**RE: PLANNING APPLICATION N^o A/114/18/PL FOR A 70 BED NURSING HOME
TO PROVIDE PALLIATIVE AND ADVANCED DEMENTIA CARE, (LOCATED
ON SITE BOUNDED BY WATER AND DAPPERS LANES ANGMERING, WEST
SUSSEX).**

**RE: PLANNING APPLICATION N^O A/114/18/PL FOR A 70 BED NURSING HOME
TO PROVIDE PALLIATIVE AND ADVANCED DEMENTIA CARE, (LOCATED
ON SITE BOUNDED BY WATER AND DAPPERS LANES ANGMERING, WEST
SUSSEX).**

DETAILED COMMENTS AND OBSERVATIONS ON THE
"RECOMMENDATION REPORT FOR PLANNING PERMISSION"
REF N° A/27/16/PL

Fig 21. Proposed site layout

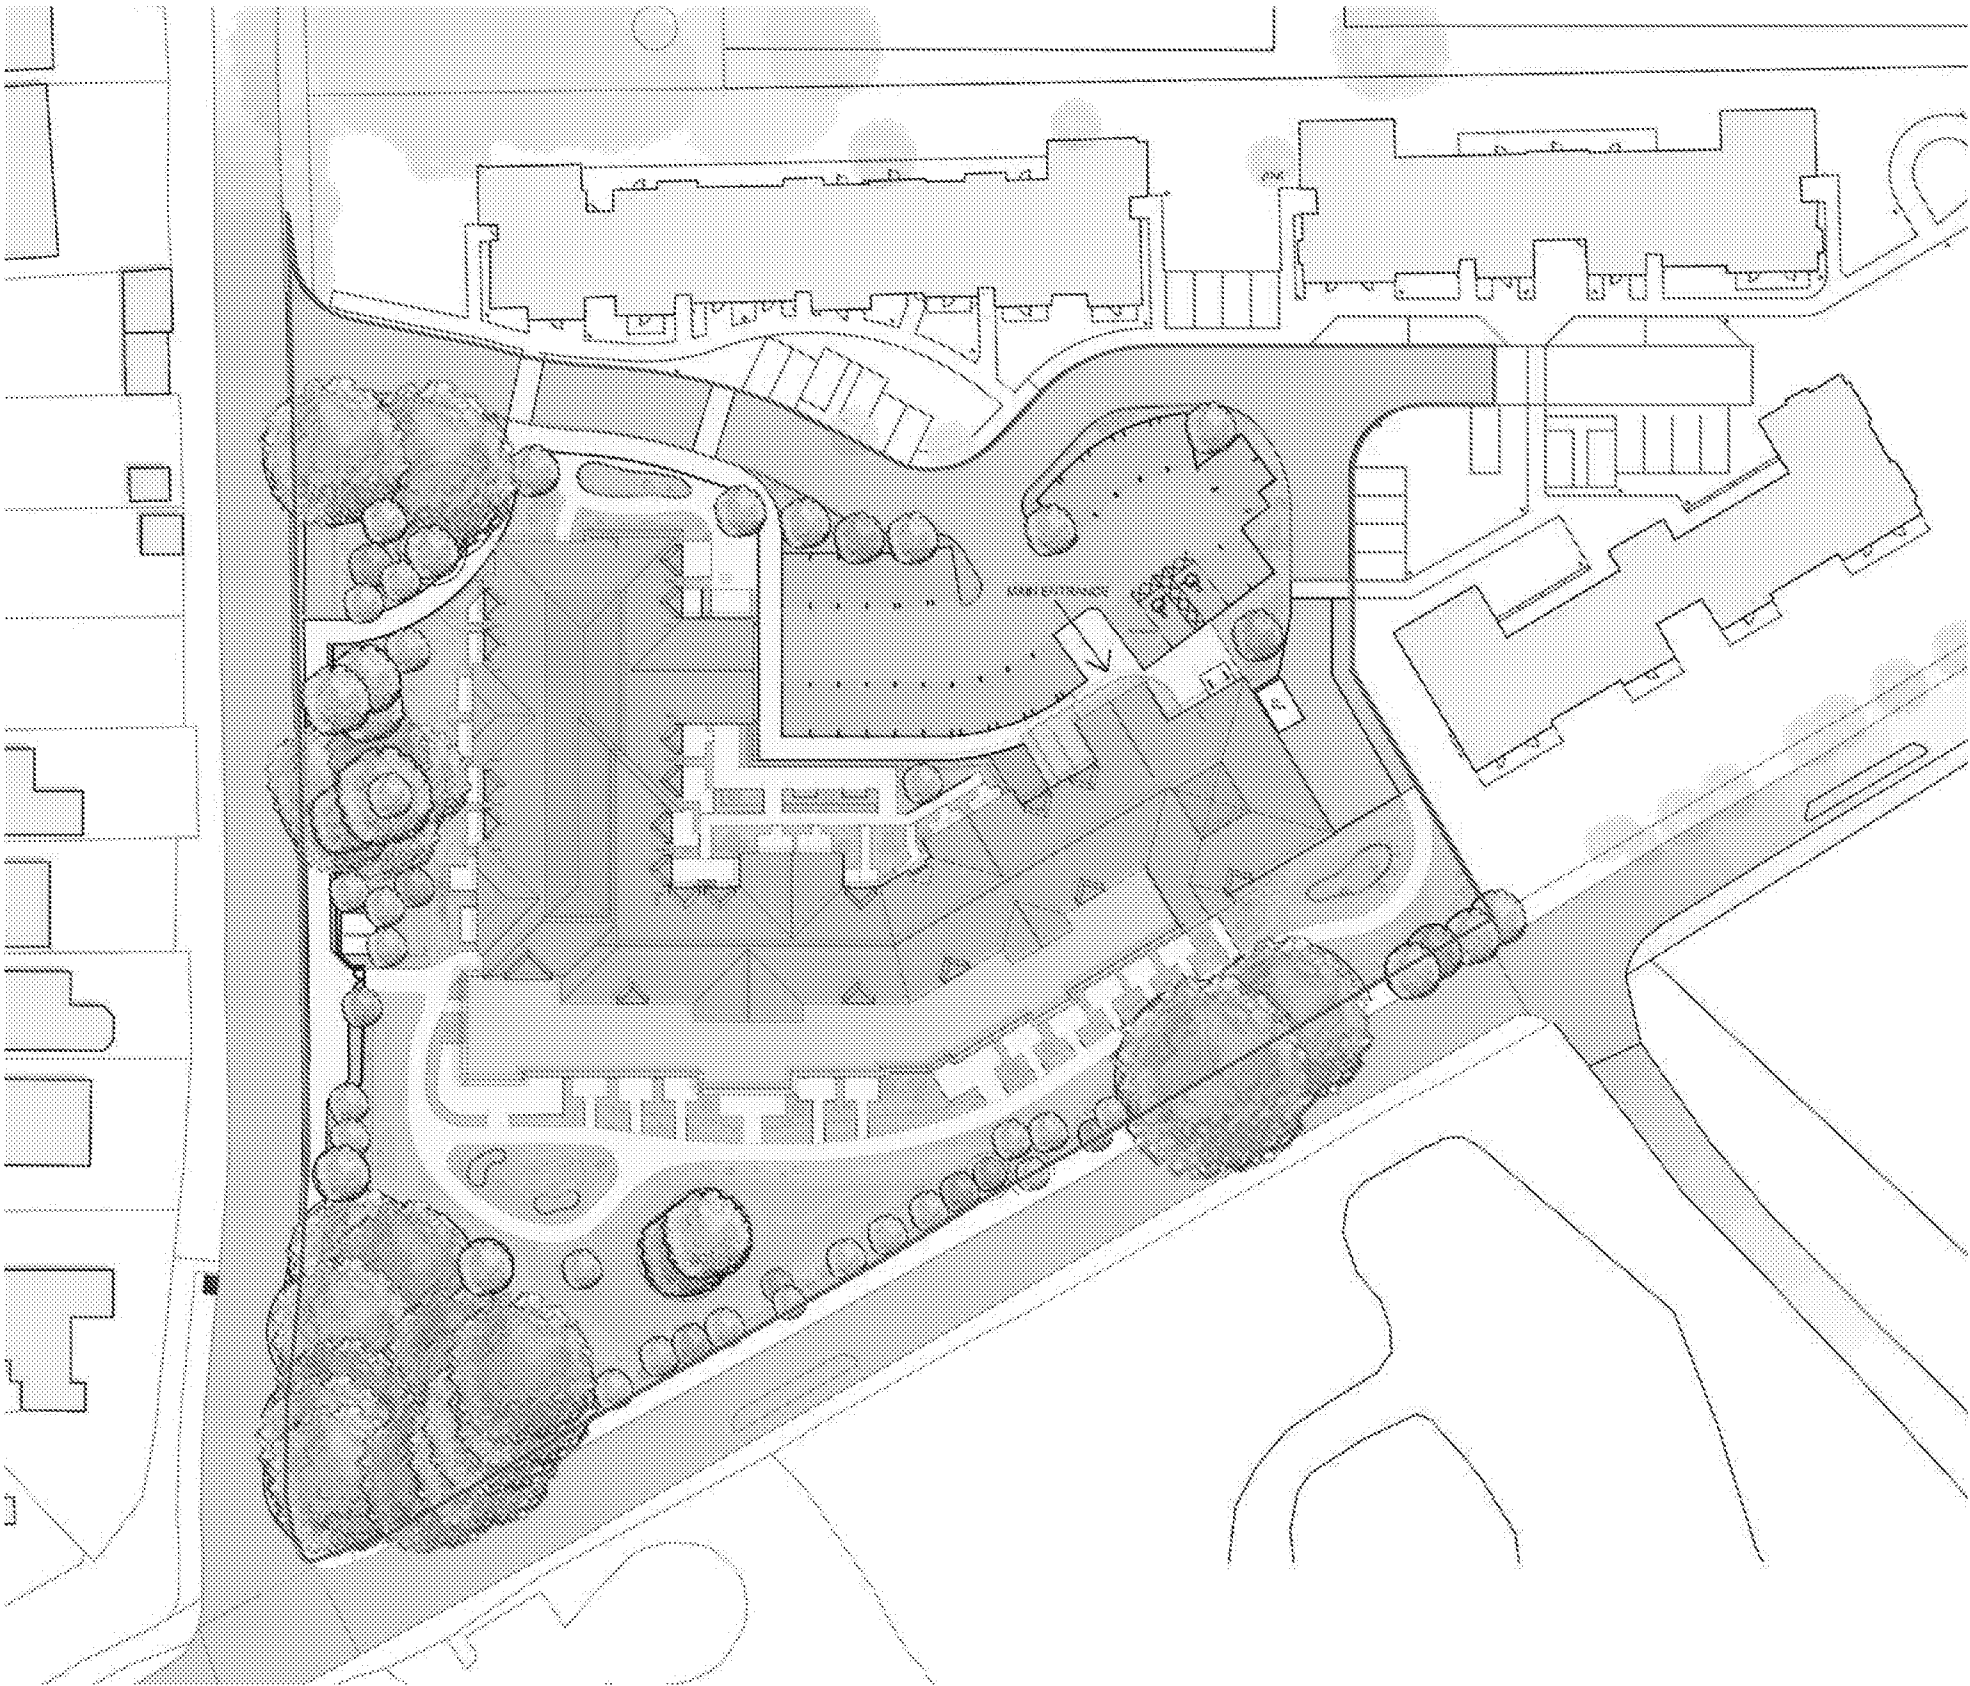
The Plot Plan for the provision of **53 EXTRA CARE APARTMENTS AND A 70 BED NURSING HOME** identifies **46 VEHICLE PARKING SPACES**. The numbers of staff coupled with visiting Doctors, Delivery Vans, Ambulances, Relatives and friends to patients will create the problem of parking in surrounding and adjacent roads which already suffer severe parking problems particularly at weekends.

The proposed entrance to the site is the current entrance to the house "BROADLEES" in DAPPERS LANE which on recent estimates would produce between 275 & 320 **ADDITIONAL TRAFFIC MOVEMENTS PER DAY TO SERVE NURSING HOME AND NIGHT SHIFT STAFF ARRIVING LATER.**

The resultant NOISE AND POLLUTION LEVELS WOULD RISE CONSIDERABLY THEREFORE CONSIDERATION MUST BE GIVEN TO PROVIDING AN ENTRANCE FROM WATER LANE RATHER THAN THE DAPPERS LANE ENTRANCE IN ORDER TO REDUCE NOISE AND POLLUTION TO NEARBY RESIDENTS IF PLANNING PERMISSION IS GRANTED.

Fig 32. Proposed Elevations - Red Line shows the previously approved scheme

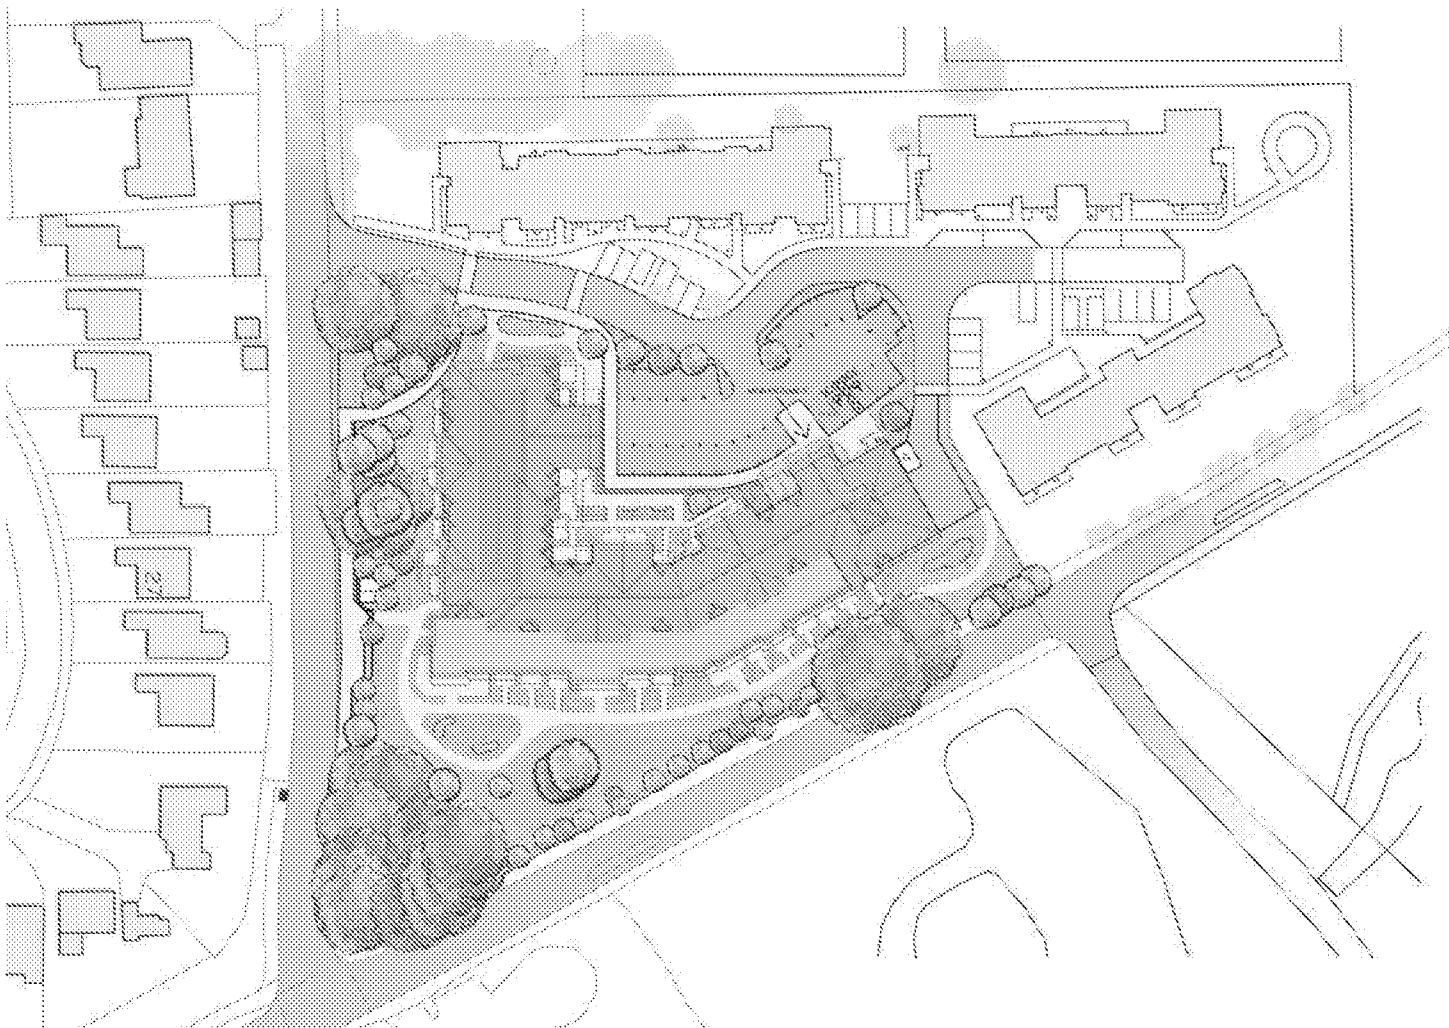
WHEN GILLINGS PLANNING ISSUED LETTERS AND COMPUTER GENERATED IMPRESSIONS TO ANGMERING RESIDENTS OF THE PROPOSED 70 BED NURSING HOME AS PART OF THE PUBLIC CONSULTATION PROCESS I CARRIED OUT A DETAILED STUDY OF THE ARCHITECT'S PLANS AND ELEVATIONS AND BECAME AWARE THE COLOURED COMPUTER GENERATED ELEVATION FACING WEST ON TO MERRYFIELD CRESCENT HOMES HAD BEEN **"ARCHITECTURALLY VISUALISED"** GIVING THE IMPRESSION TO THE UNTRAINED EYE THAT THE NURSING HOME OVERALL HEIGHT WAS NOT AS HIGH AS IN FACT IT WOULD BE, I DECIDED TO CONSULT AN EXPERT IN **"ARCHITECTURAL VISUALISATION"** TECHNIQUES WHO CONFIRMED MY SUSPICION THAT MANIPULATION OF VIEWS OF ELEVATIONS HAD BEEN PRODUCED TO REDUCE THE IMPACT OF ACTUAL NURSING HOME MASS AND HEIGHT.

THE SECOND FLOOR ACCOMMODATION IS TO BE PROVIDED WITHIN THE ROOF SPACE AND IN ORDER TO COMPLY WITH BUILDING REGULATIONS, THE REQUIRED HEADROOM WITHIN THE APEX ROOF SPACE IS MUCH HIGHER WHICH RESULTS IN BUILDING HEIGHT BECOMES A THREE STOREY AND NOT A TWO STOREY AS GILLINGS PLANNING HAS STATED.

THE OVERALL HEIGHT IS FURTHER EXACERBATED BECAUSE DAPPERS LANE GRADIENT DROPS DOWN TO WATER LANE RESULTING IN AN EVEN GREATER HEIGHT DIFFERENTIAL WHICH WOULD OVERLOOK DOMESTIC HOMES NUMBERED 25, 27, 29, 31 & 33 MERRYFIELD CRESCENT AND HOMES BEING JUST OVER THIRTY FEET AWAY (30'-0") FROM THE NURSING HOME THEREFORE THE MASS AND HEIGHT OF THE BUILDING WOULD INAPPROPRIATLY DOMINATE OVER THE HOMES OF NEARBY RESIDENTS BEING CLOSE TO THE HEIGHT OF A FOUR STOREY BUILDING WHICH IS UNACCEPTABLE ON BASIC TOWN PLANNING CRITERIA FOR SUCH A LOCATION AND ITS PROXIMITY TO EXISTING DOMESTIC HOMES.
